Revised October 14, 2020

Project No: 19-3028

17055 Red Barn Road, Peyton,  
El Paso County, Colorado

# SOILS INVESTIGATION FOR THE ON-SITE WASTEWATER TREATMENT SYSTEM (OWTS)

PINE VIEW ESTATES
 THE SOUTHWEST QUARTER OF THE NORTHWEST QUARTER
 SECTION 13, TOWNSHIP 11 SOUTH, RANGE 64 WEST OF THE 6TH P.M.
 COUNTY OF EL PASO, STATE OF COLORADO

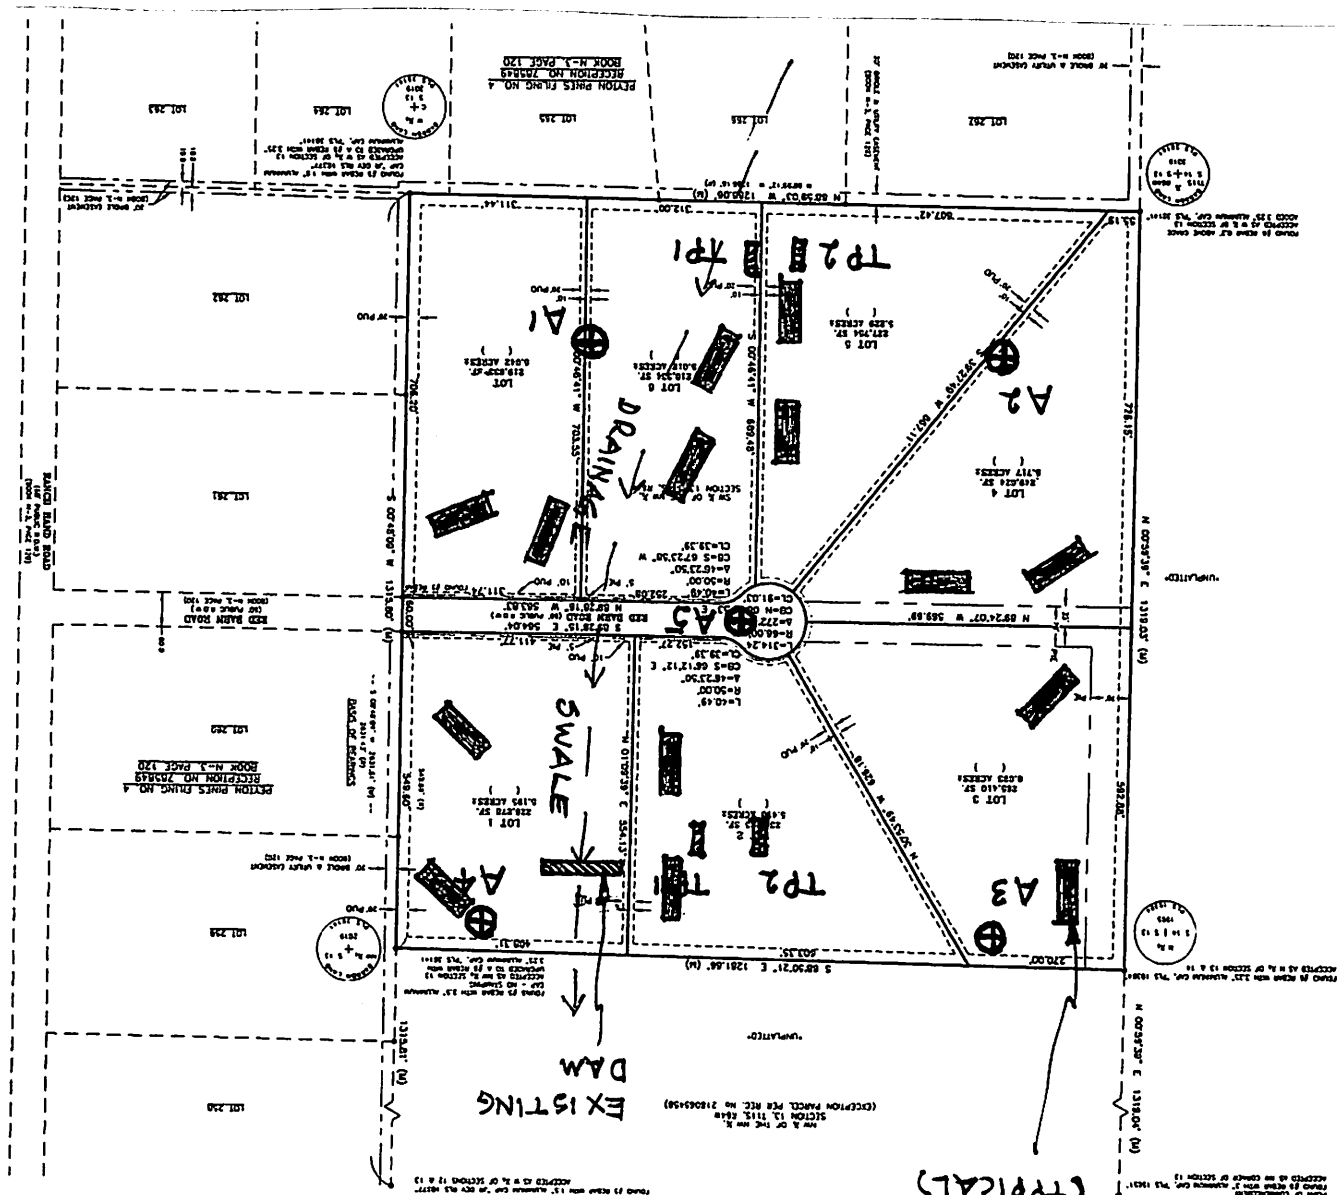
**Please see previous comment from Review #1 that has not been addressed:**

"Per LDC Section 8.4.8 (C), the OWTS report should demonstrate that each lot proposed has a minimum of two sites appropriate for OWTS which do not fall into the restricted areas shown on the Preliminary Plan, soils and geology report, or delineated wetland or floodplain maps. There is no map showing the lots and the studied and acceptable locations for two potential OWTS sites per lot."

Please refer to the following resolution for updated requirements for the OWTS report. See Specifically Section 8.4.8(C) and Section 8.4.8(E)(2)(e)
